## **GLEBE FARM MARINA CLAYDON**

**Revised Application Ref. No. 20/02446/F**

### **OBJECTION STATEMENT BY ROBERT ADAMS B.Sc. *Landscape Architect (retired)***

Appendix F – Flood Map Overlay with Proposed Development

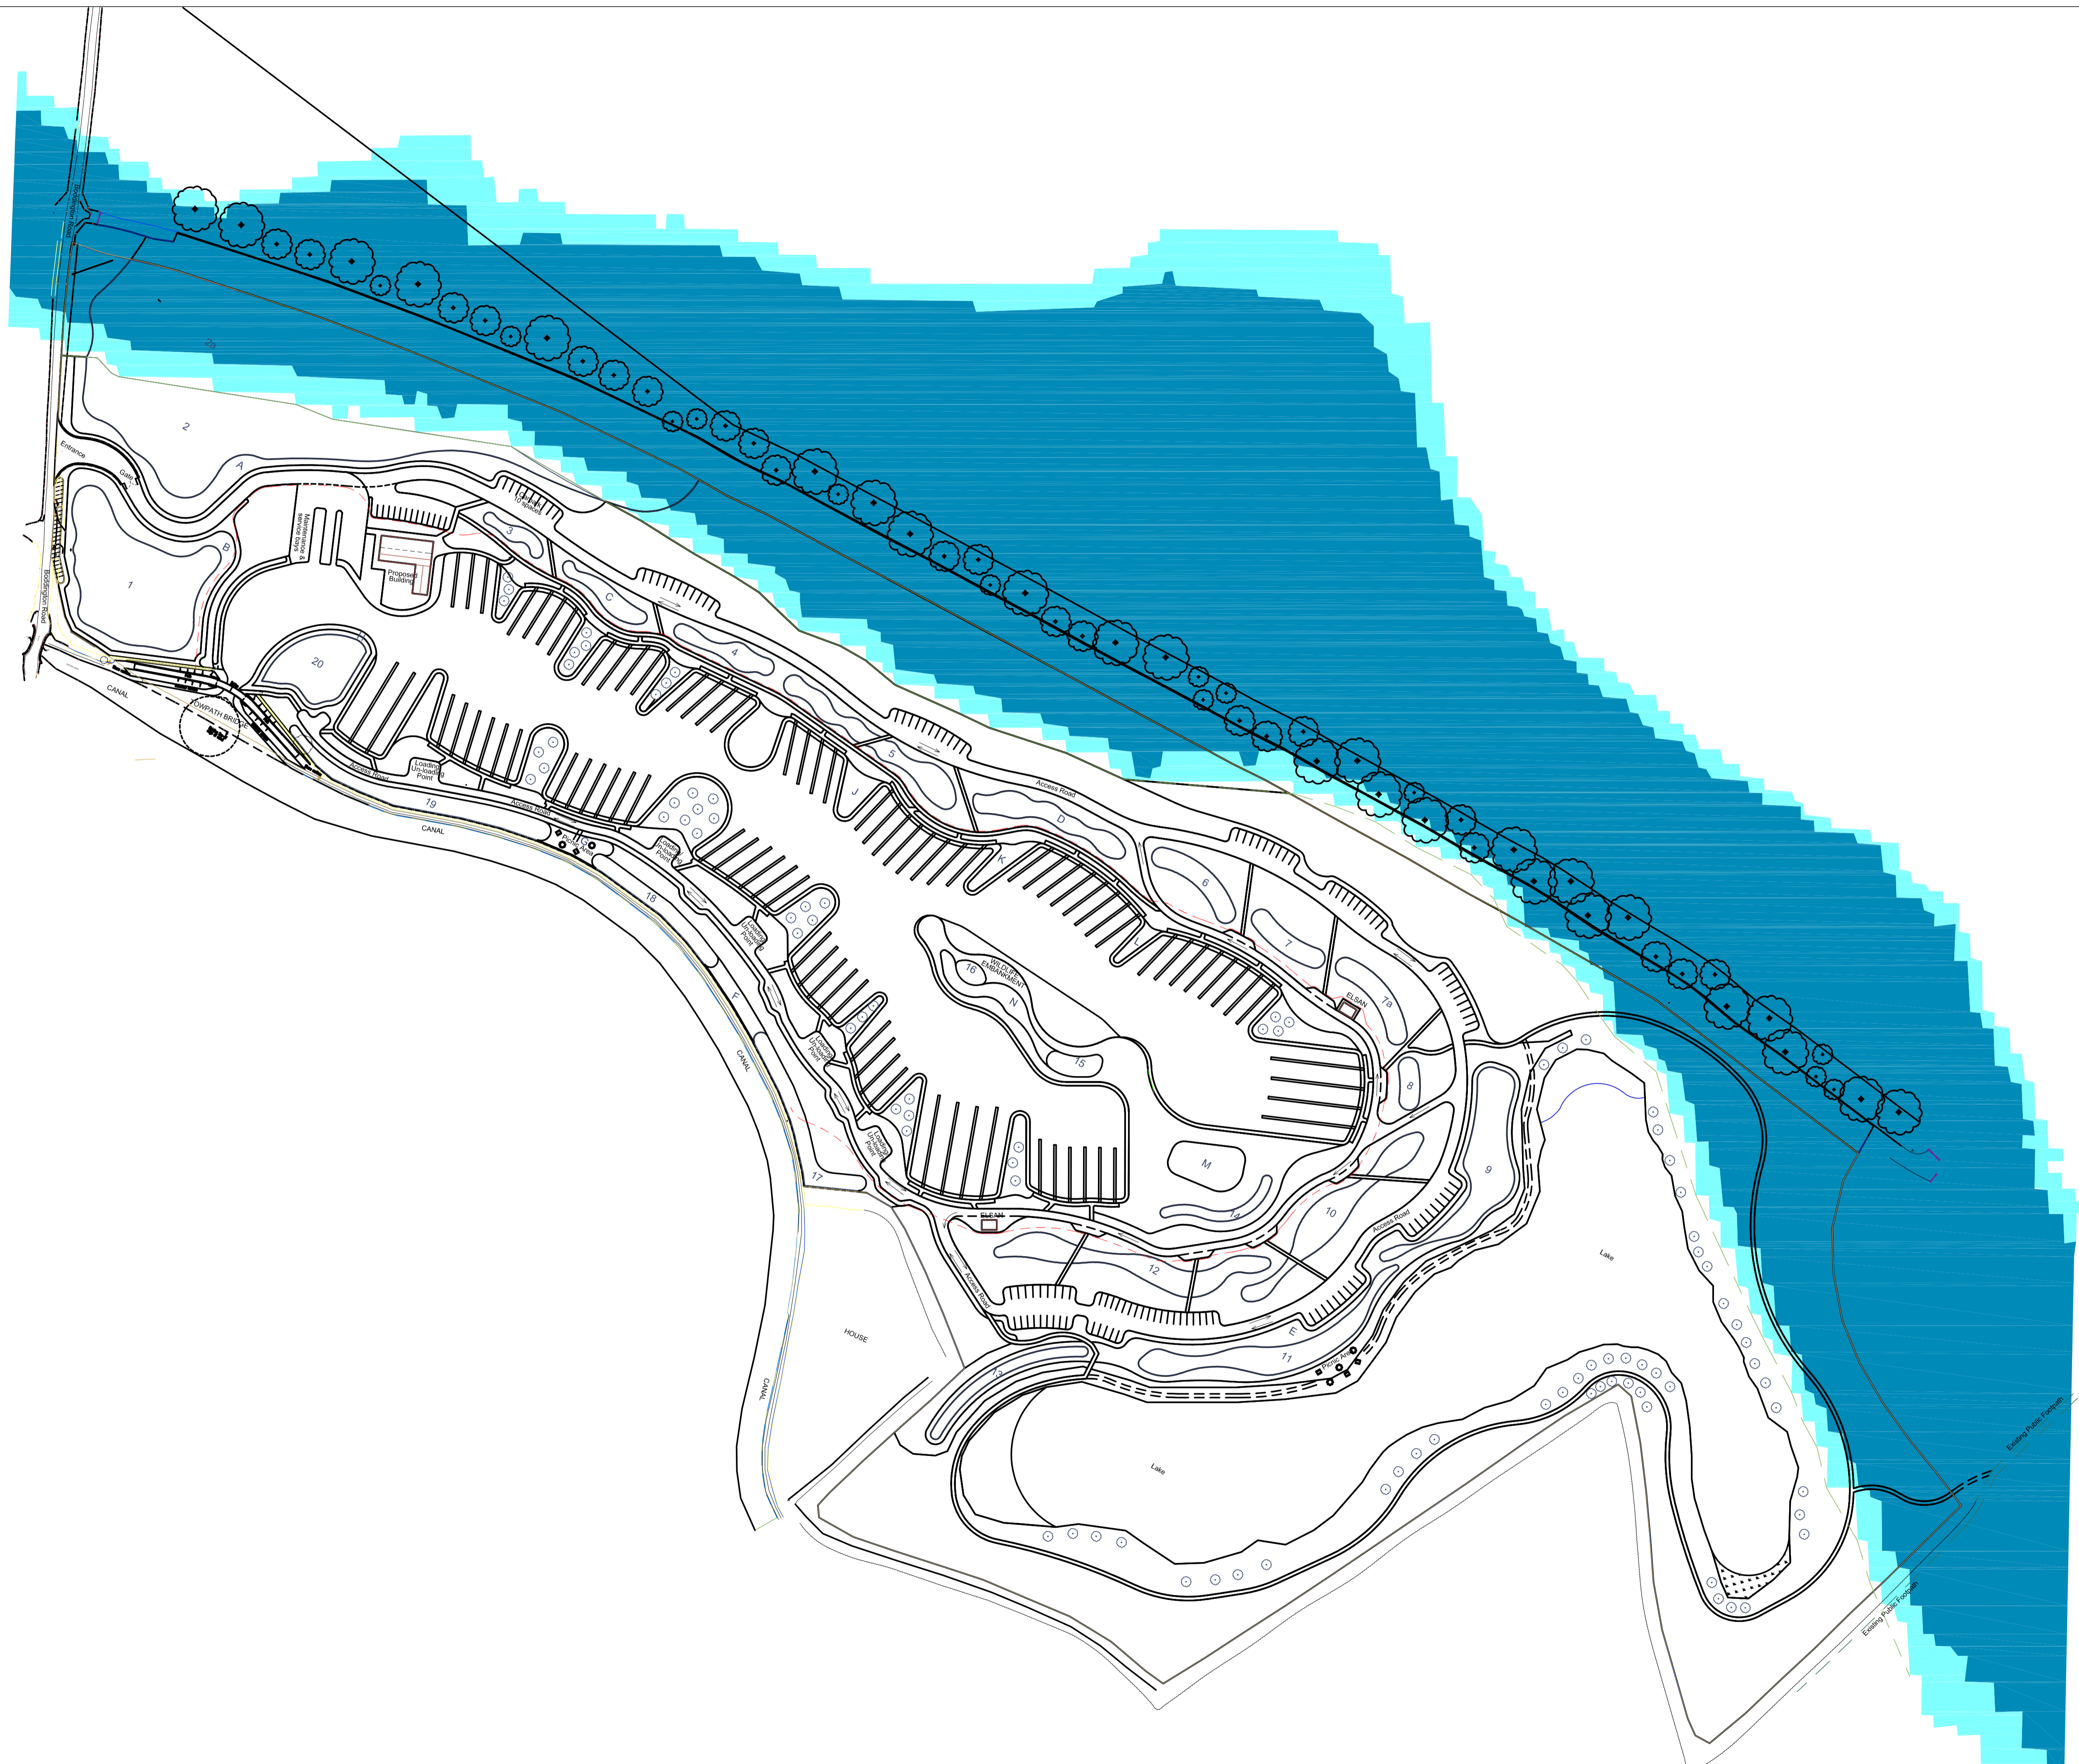
1.7 Flooding occurs periodically and the canal has overflowed. This has been basically ignored as no proposals are indicated to mitigate the effects of flooding into the marina.

PROPOSED SECTION A-A

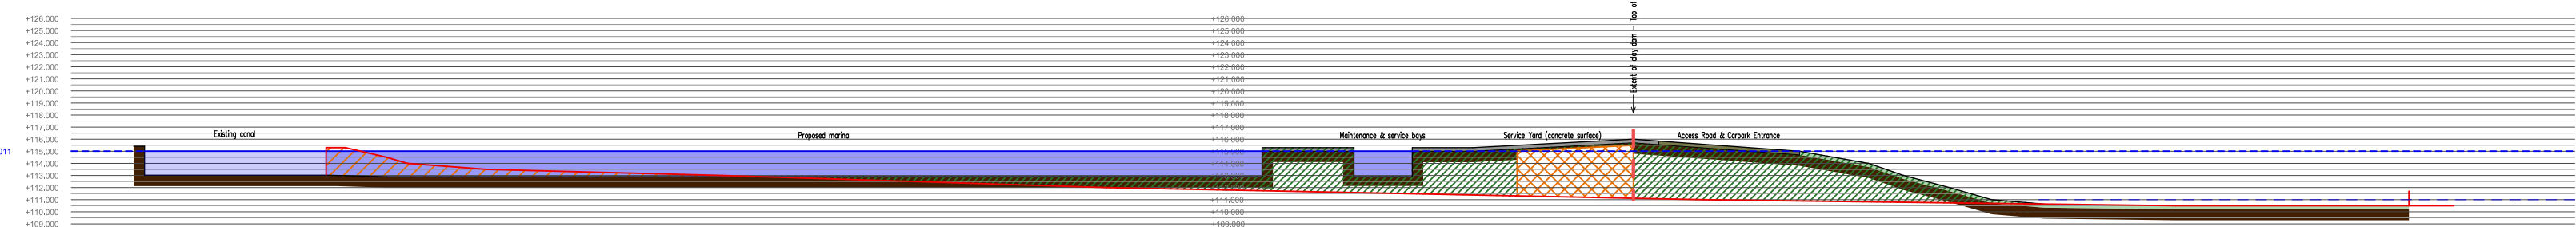
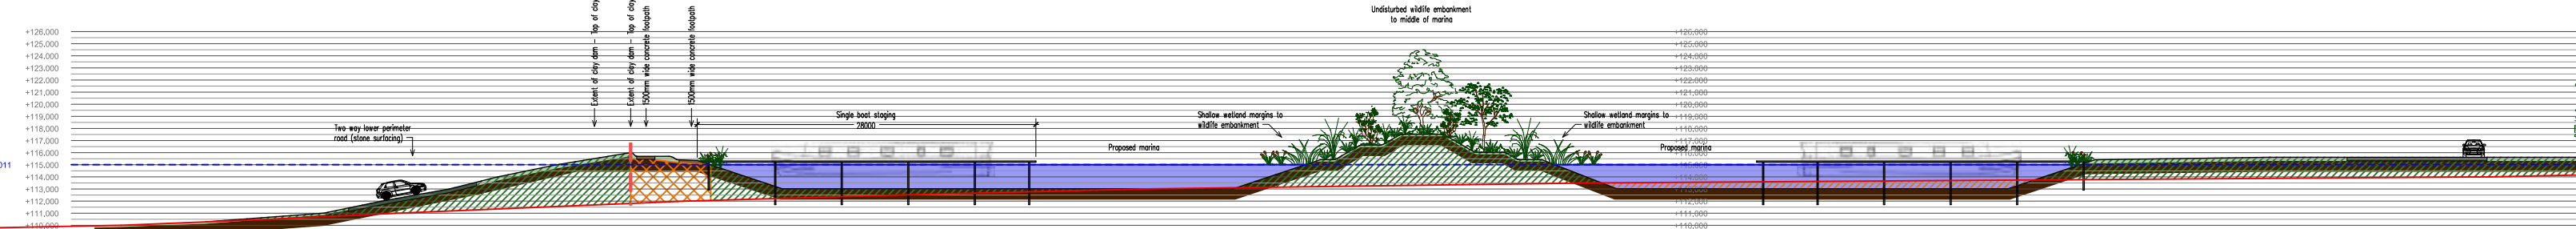
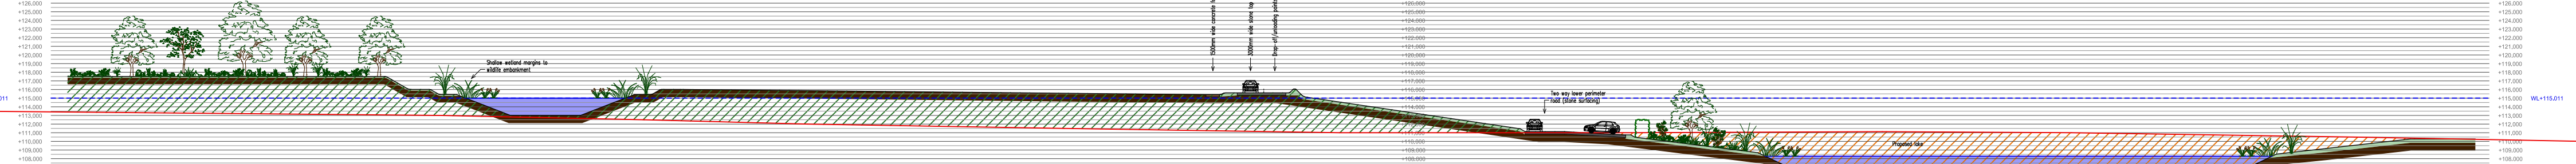
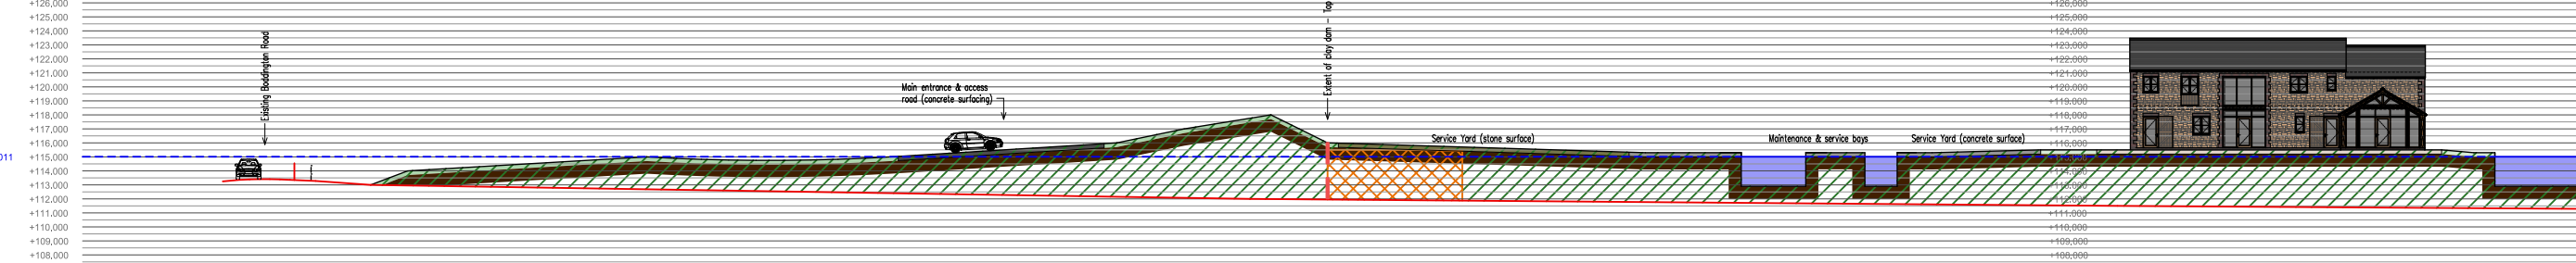
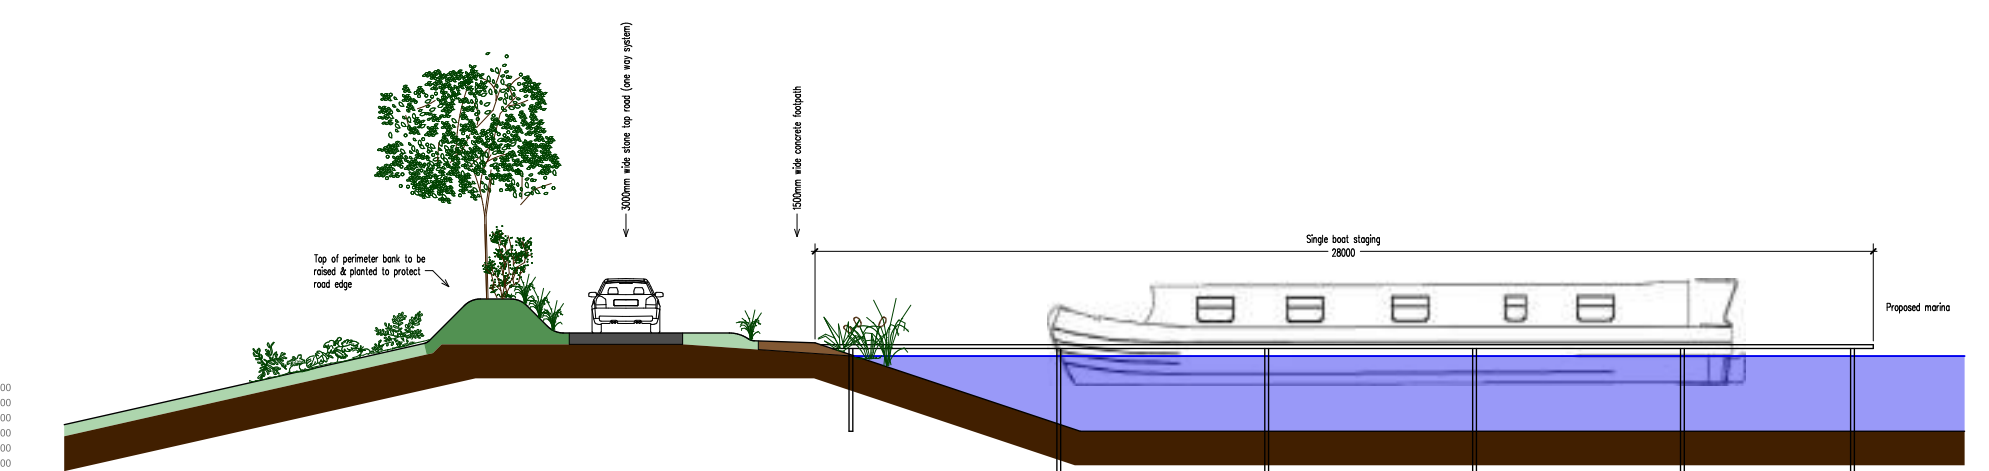
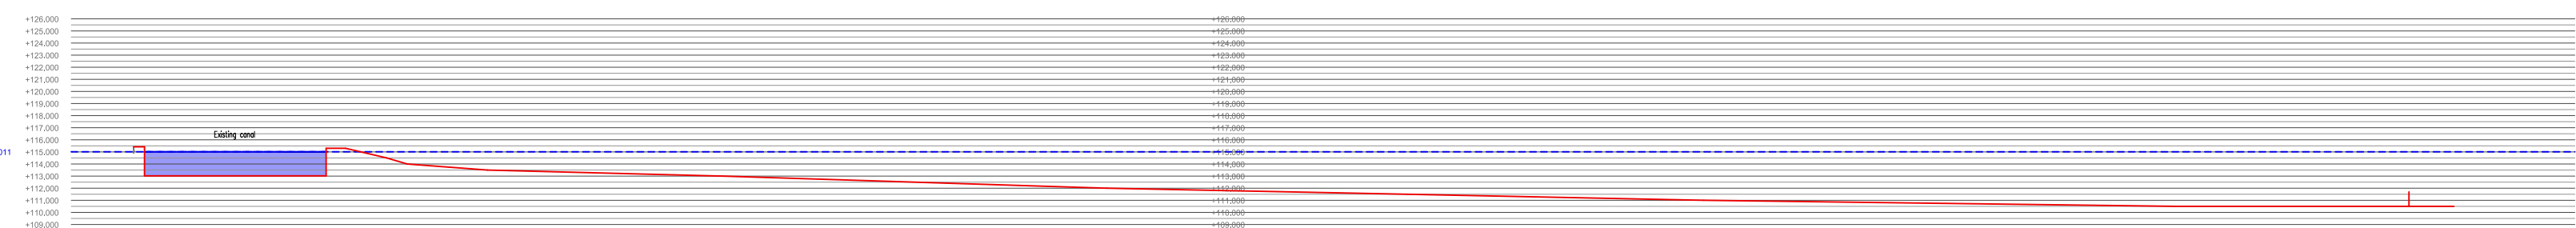
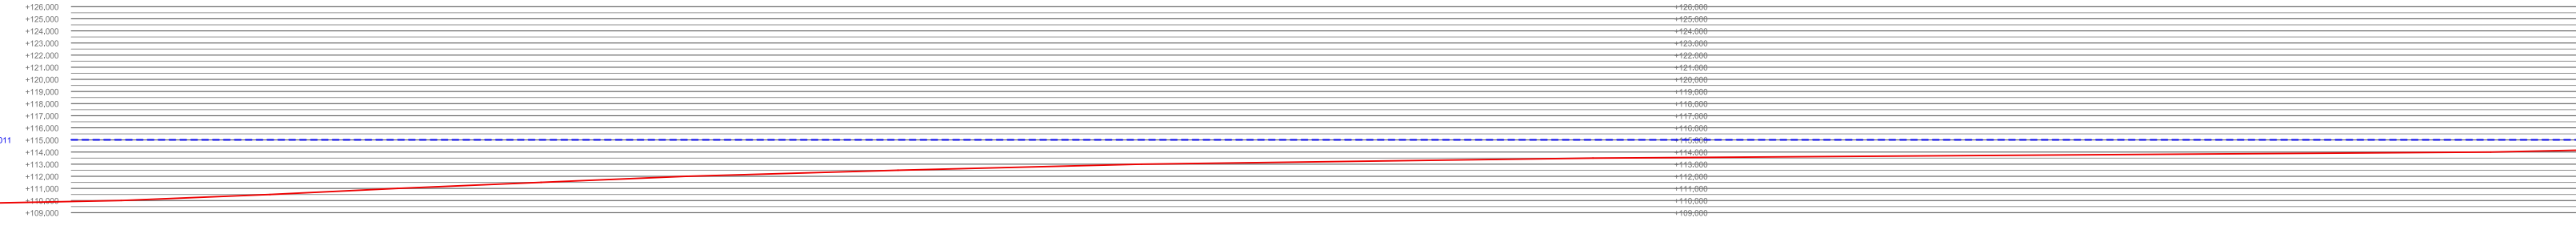
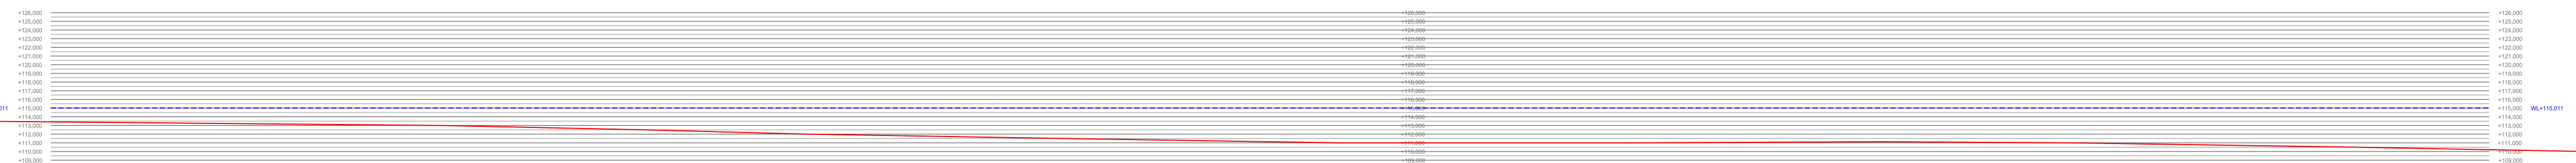
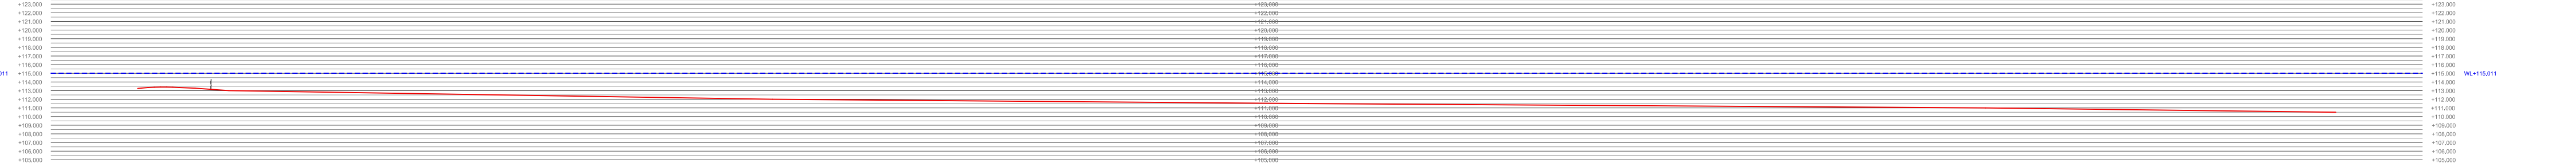
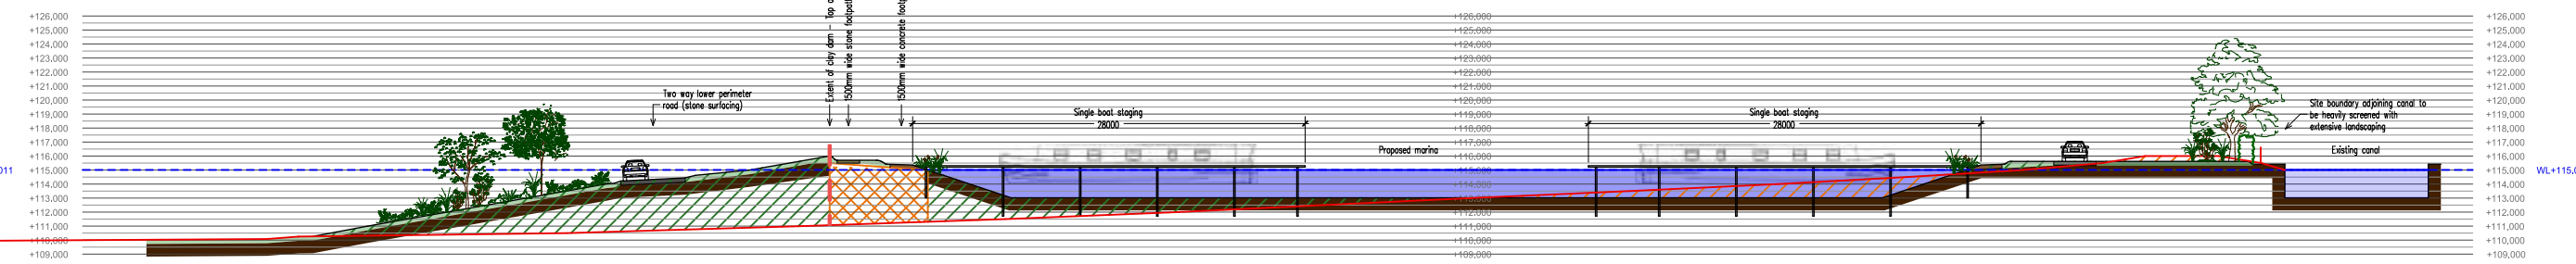
1.3 Visual Impact would be caused by large earth bunds east of the Lower Boddington Road which would obliterate views over a traditional and historic landscape, also changing the nature of the views of the historic Canal. Current amenity values would be lost.

1.4 Landscape Impact would be extremely significant and severe. Land form amendments would introduce land forms that do not exist elsewhere in this local landscape. The former railway land, which is unaffected by the proposals, is level with the site. It is now a public footpath and the new marina embankment alongside it would completely change the views of the Canal and landscape from the footpath.

1.11 Drawings for this project have been poor throughout because they are both difficult to read (levels, contours, etc.) and to understand (the scale of the proposed embankments and the reason for their inappropriately massive scale, etc.).
